# CITY OF ALBUQUERQUE

**Re: Building Addition**  
**3400 Columbia Dr. NE**  
**60-Day Temporary Certificate of Occupancy**  
**Transportation Development Final Inspection**  
Architect's Stamp dated 04-27-21 (G16-D139A)  
Certification dated 03-23-23

TCL PLAN

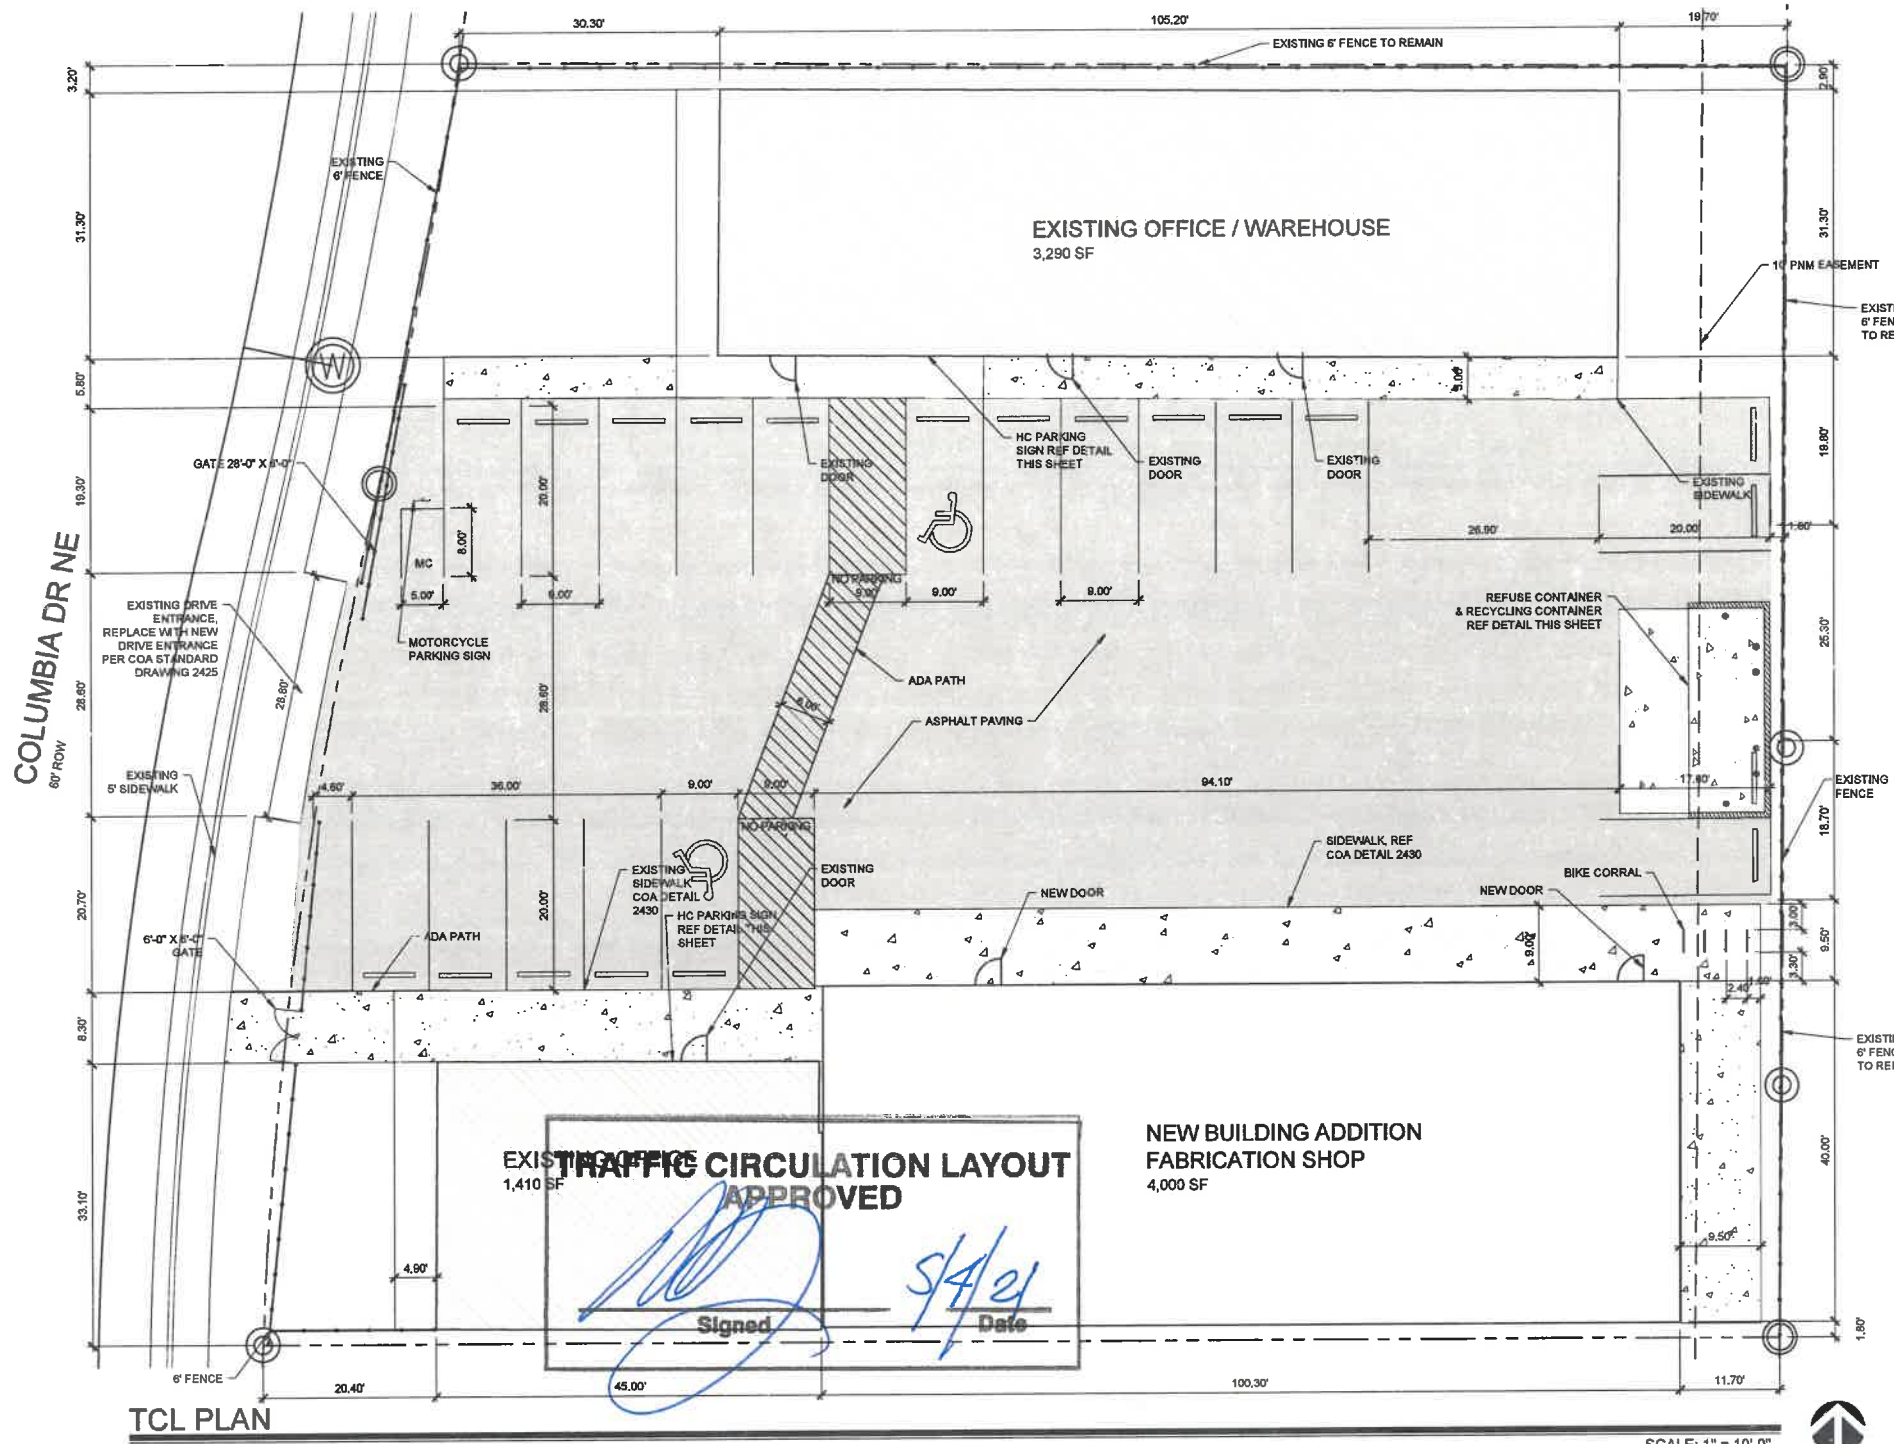
- Please provide a "Van" sign for one of the provided ADA parking spaces.
- The pavement marking "MC" should be shown in the opposite direction for Motorcycles entering the parking space.
- Per approved site plan, please build the site access's drivepad per city std 2425.
- Please fix or replace all the broken and cracked sidewalk, as mentioned in the general note on the approved site plan.
